From: Gary Bottwood [redacted]
Sent: 05 May 2021 19:25
To: Finlay Gardner <Finlay.Gardner@arun.gov.uk>
Subject: Re: Planning resubmission BE/59/21/HH

SITE PLAN - SHOWING VISIBILITY SPLAYS
1:500 SCALE (at A3)

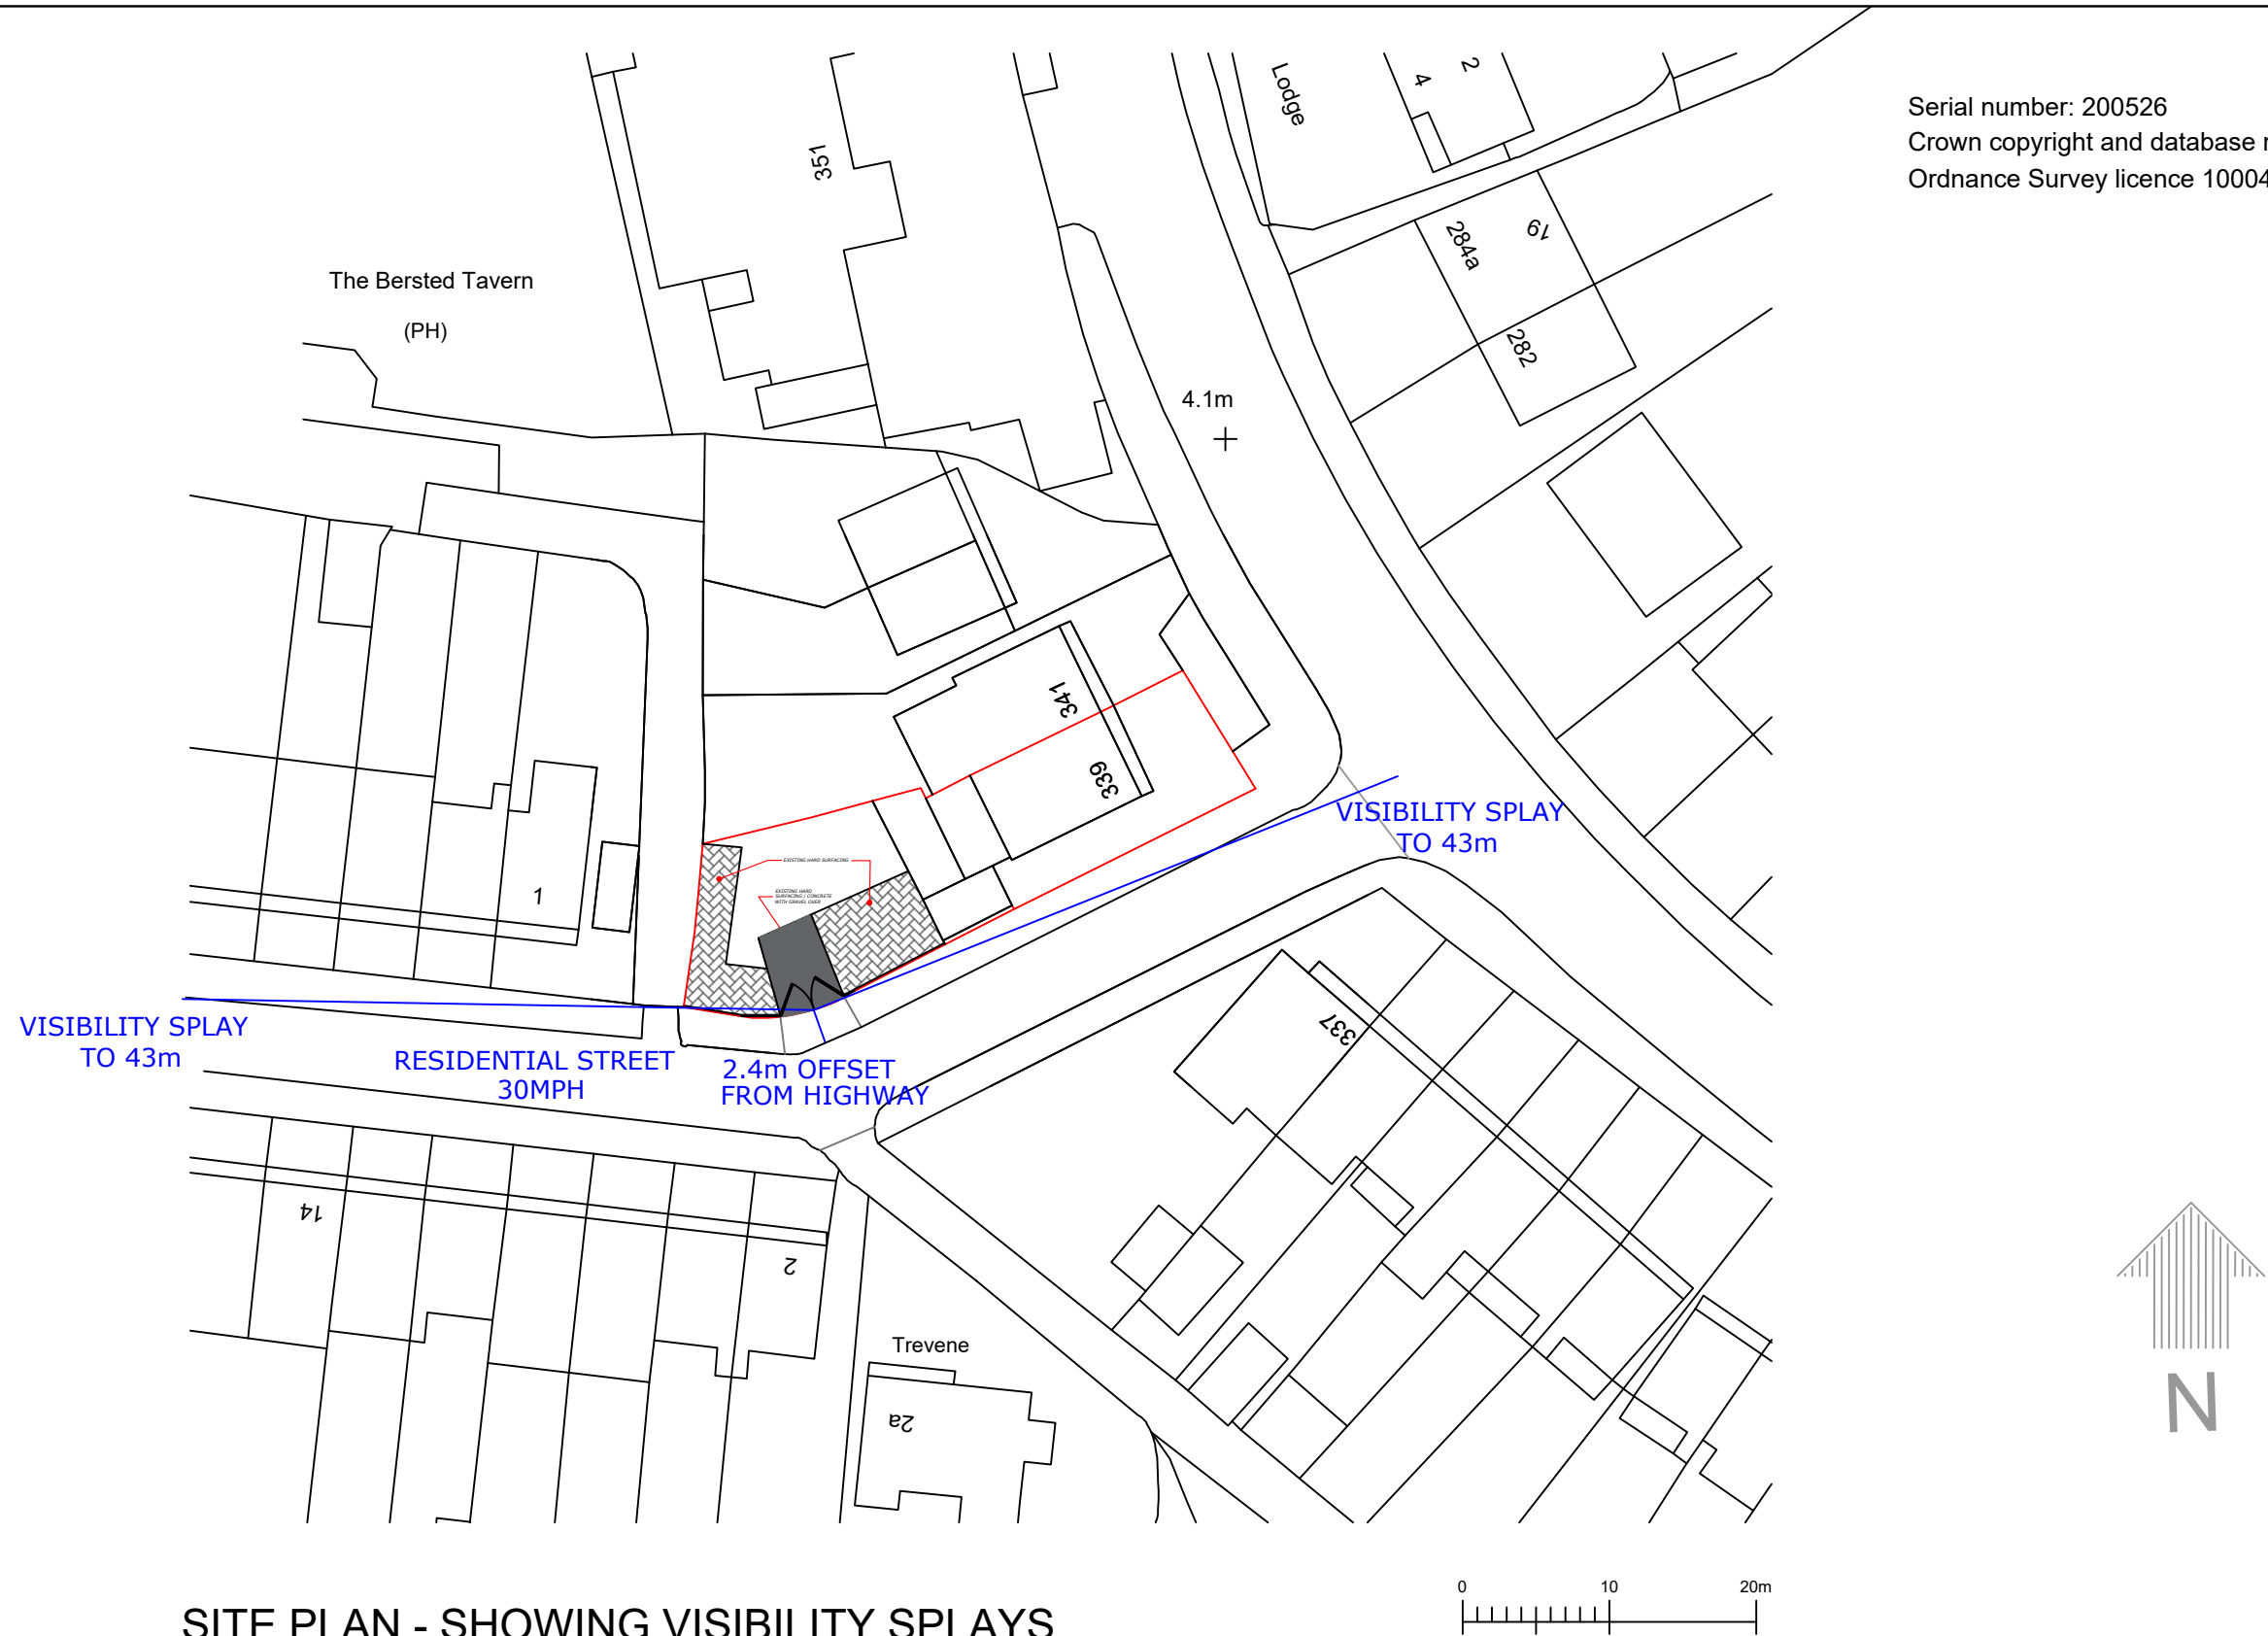
fence to be 600mm. This hasn't been addressed within the new plans nor previously. In fact the original Retrospective planning Application was withdrawn after Mr Delaney was repeatedly asked to submit plans addressing this and ignored all requests. It appears he has failed to address this in this resubmitted application with the fencing being too tall to satisfy the Drop Kerb Licence Conditions.

The other issue with the revised Application is the positioning of the Drop Kerb In the drawing. The drawing suggests it is on the apex of the bend where as it is actually flush with the wall in the direction of Chichester Road. Unless Mr Delaney intends to extend the Drop Kerb 1m towards Chalcroft Lane it isn't an accurate representation of its physical position. This may seem minor to someone looking at the drawing but it benefits Mr Delaney in his attempt to prove visibility is better than it is.

We are aware that a planning application has been resubmitted and the residents of Bedford Avenue are asking me where they can object. The plans only differ by hVing lines added to indicate visibility splays. However the splays do not account for trees adjacent to the property reducing visibility to far less than the 43 Mtrs required.

The fence is not compliant with the 600 mm maximum height required by highways as ordered by Ben Whiffin as a condition of the licence being issued in September 2019. As there has been no subsequent inspection the renewal of the Drop Kerb licence would be issued under the same conditions required by Ben Whiffin.

All in all this new planning application hasn't addressed the issues raised by ourselves when he first applied. He has failed to address the visibility issue as the plans have just had a couple of lines added. There has been no speed test as suggested by Highways themselves due to the inability to satisfy the necessary distances required.
